DECISION DELEGATED TO HEAD OF PLANNING

Application No: H09-0513-24 **Applicant:** Miss R Lee

Proposal: Demolition of existing dining room, conservatory and garage and rebuild - Approved under H09-0306-21 - Amendment to external finish

Location: 82 Battlefields Lane South Holbeach Spalding

PLAN AS PROPOSED

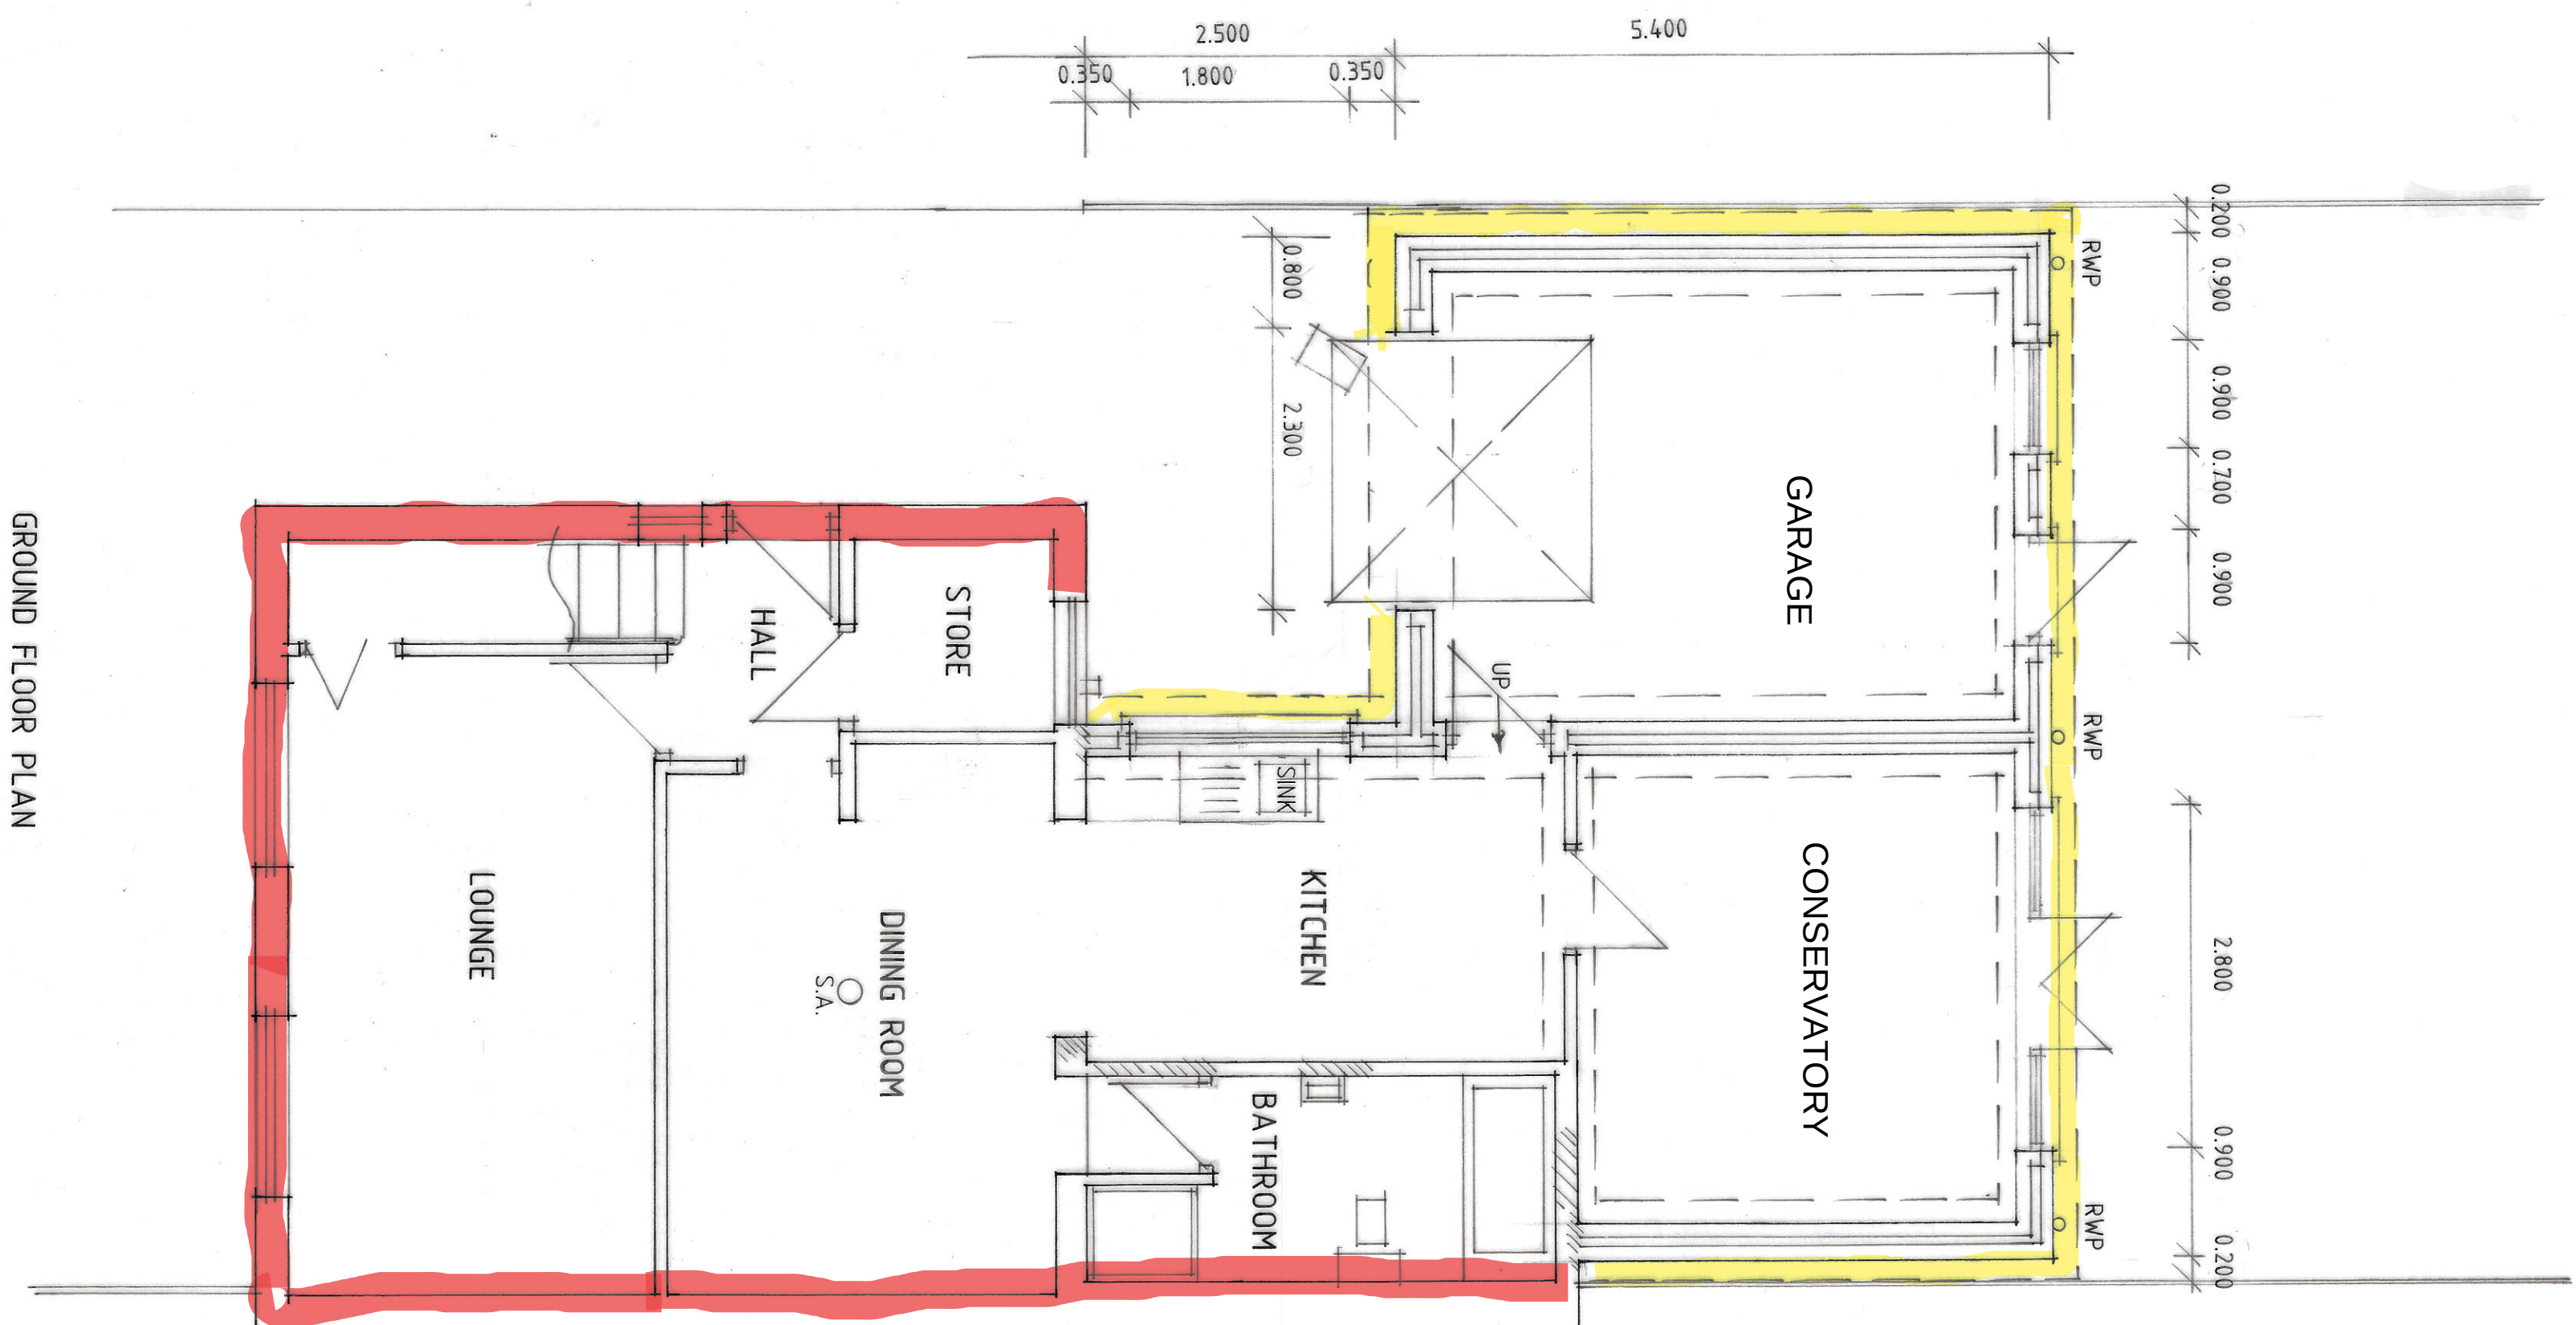
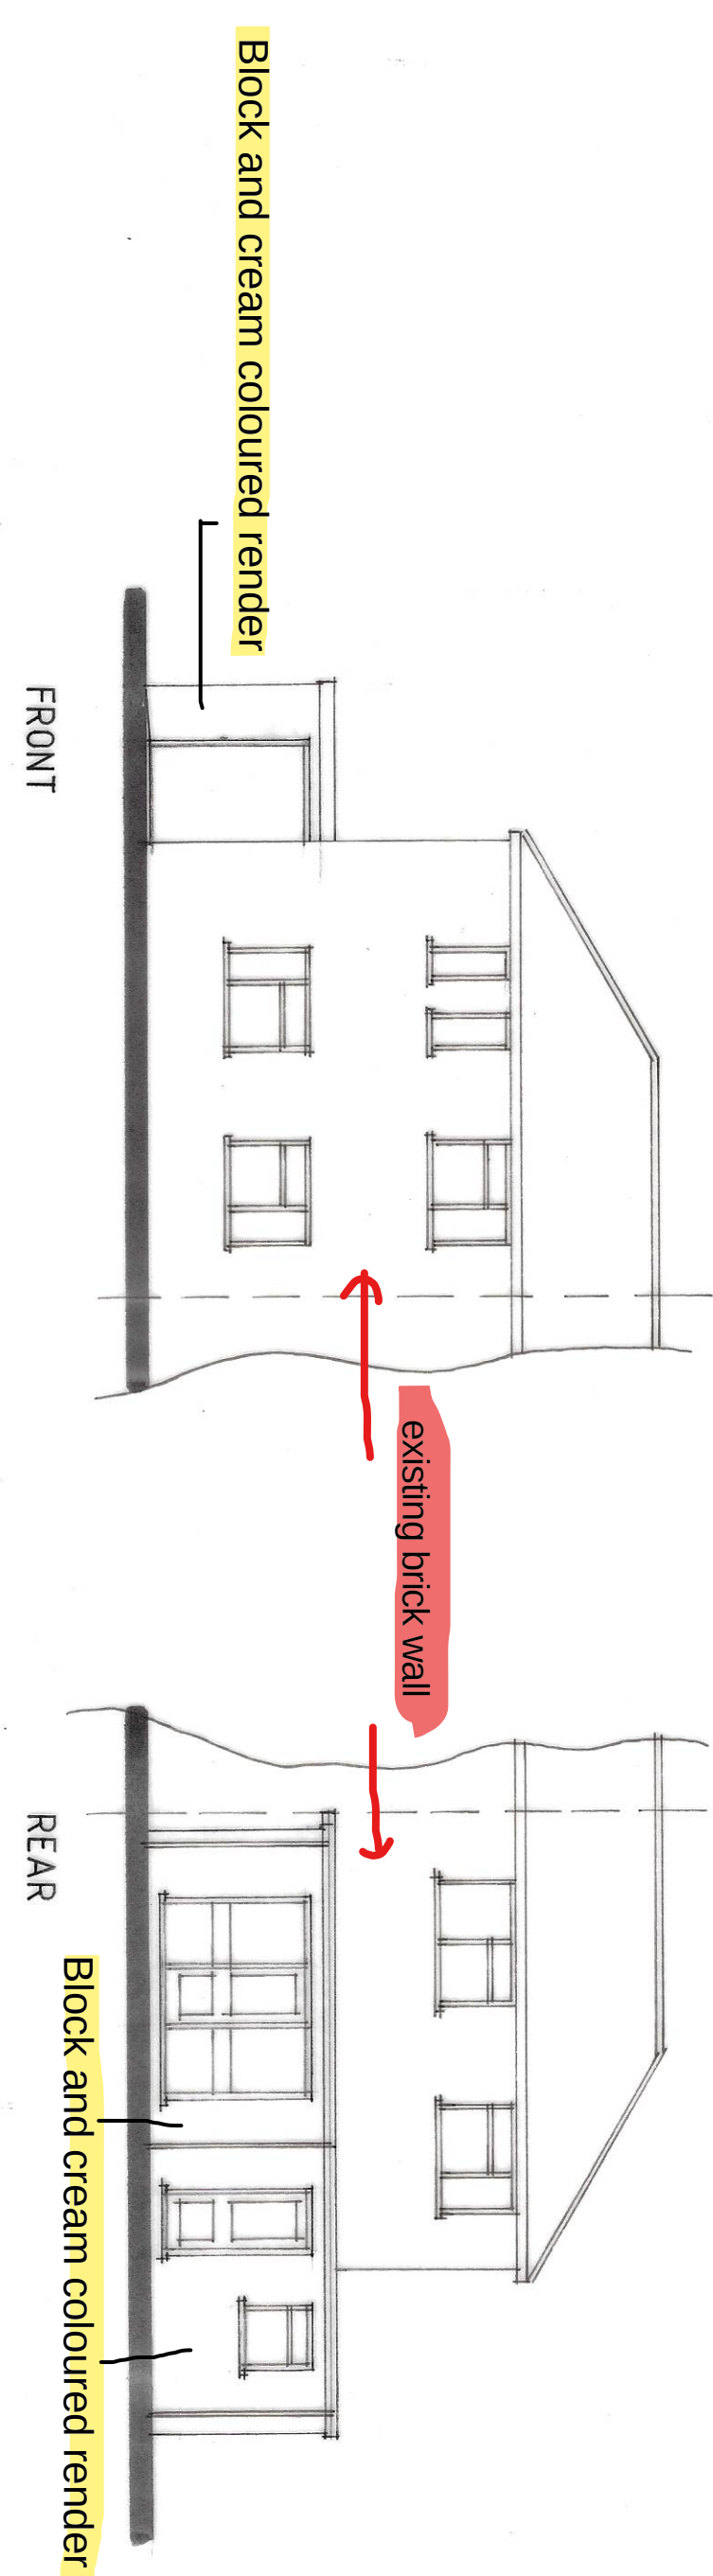
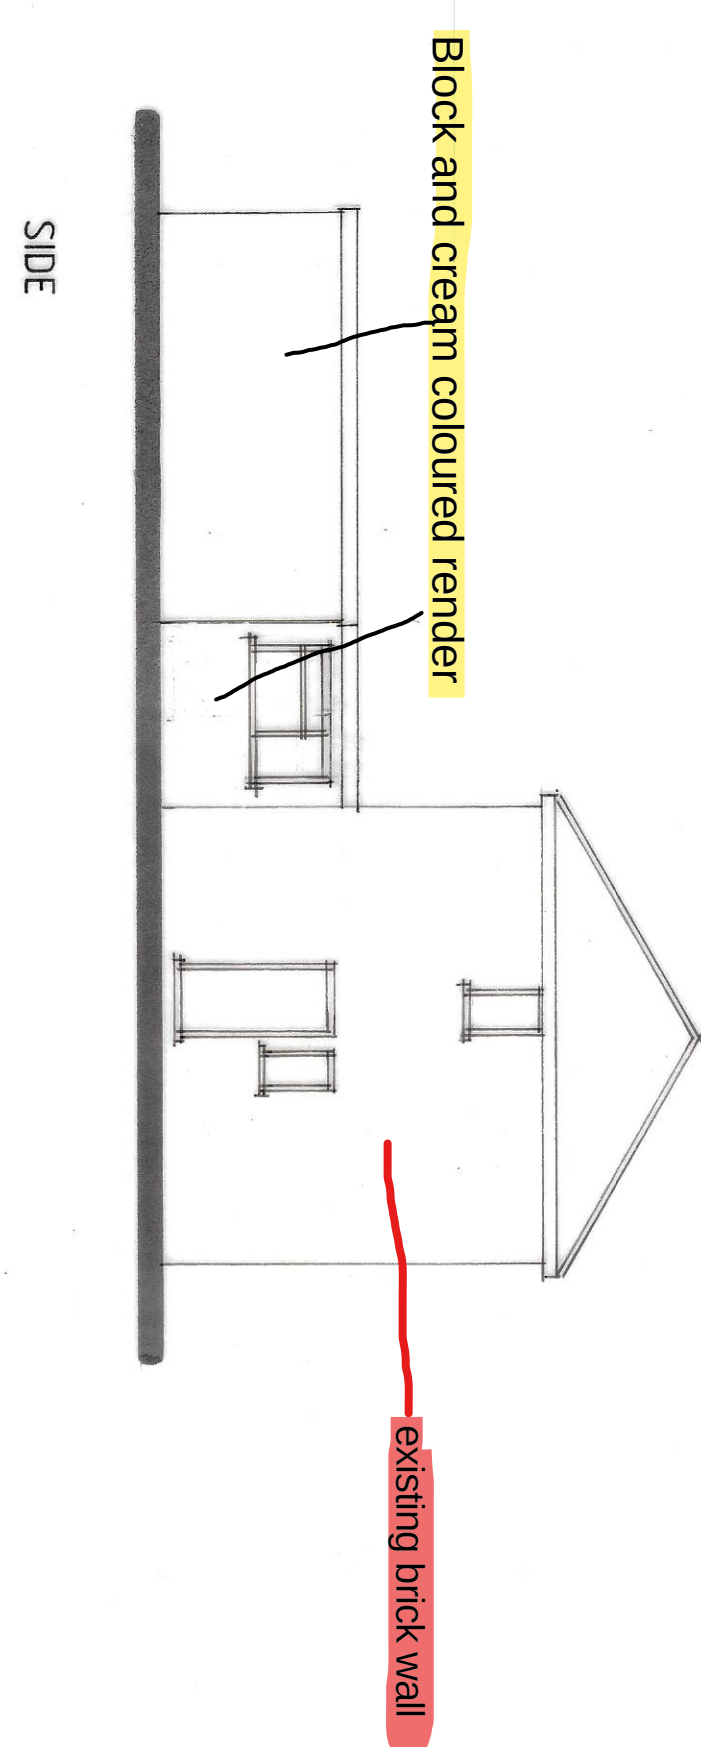
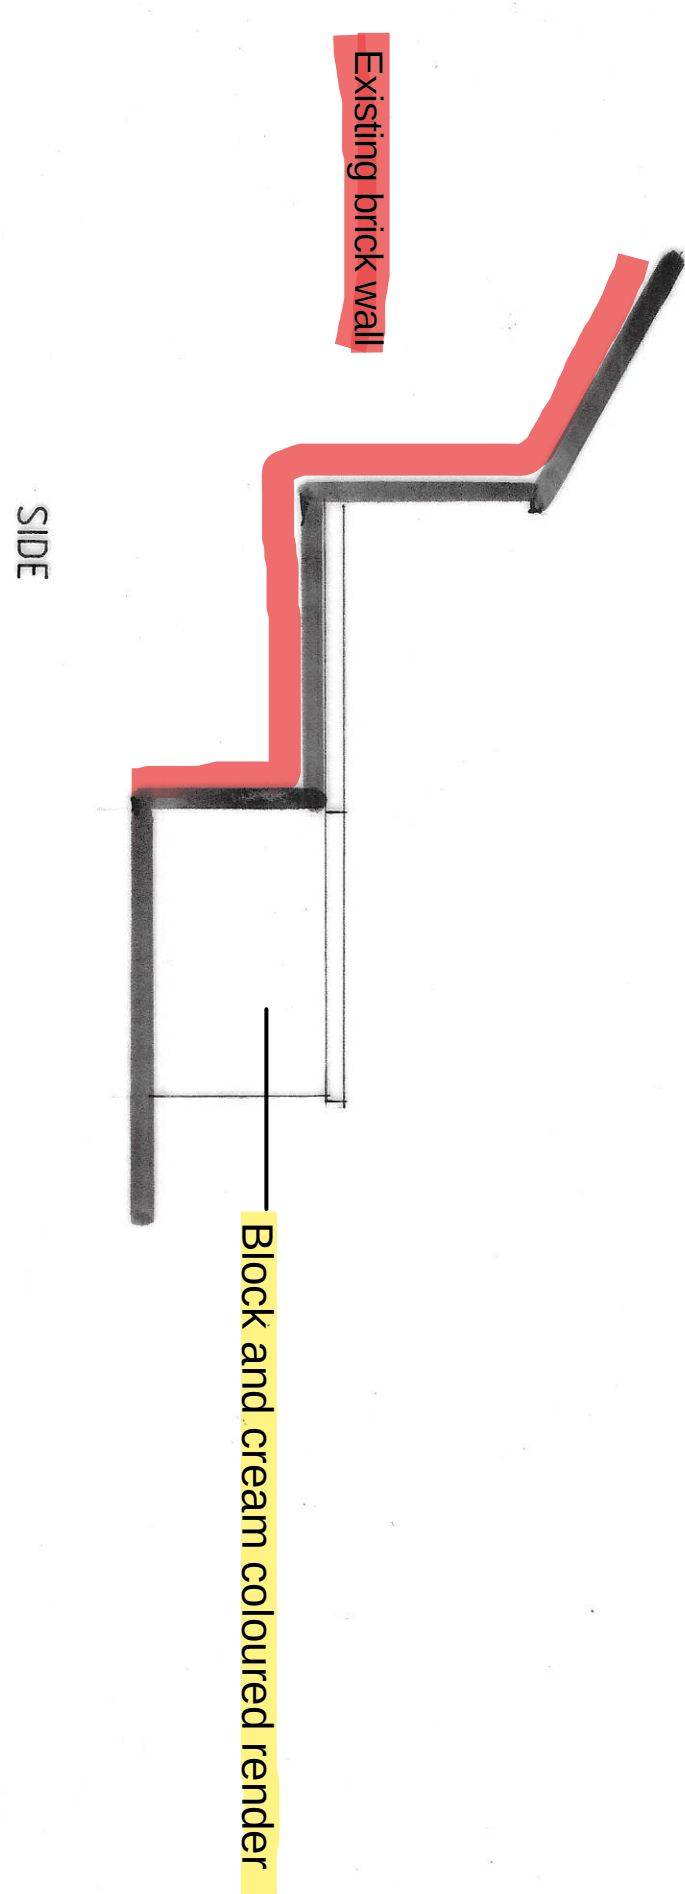
This is a non material amendment application, seeking amendments to the external finish approved under H09-0306-21. It is proposed that the brickwork to be used for the rear extension, approved under H09-0306-21, would be replaced with rendered blockwork. Cream render would be used.

3. Condition 3 of the H09-0306-21 states that "all new and replacement brickwork utilised in carrying out the development hereby permitted shall match as closely as possible that of the principal existing building on the site in terms of the type of brick(s), mortar mix and method of bonding." The removal of this brickwork does not strictly conflict with this condition.

8. The addition of render would not fundamentally alter the design of the extension. The extension would be largely obscured from the public realm, ensuring there is a minimal character impact regardless of the materials used. Render is already present within the wider area, and as such would not appear anomalous. Under permitted development rights, the host dwelling could be rendered regardless; the alterations must be considered in this context.

It is considered that the amendment proposed is acceptable and can be considered a non-material amendment. The recommendation is for delegated approval
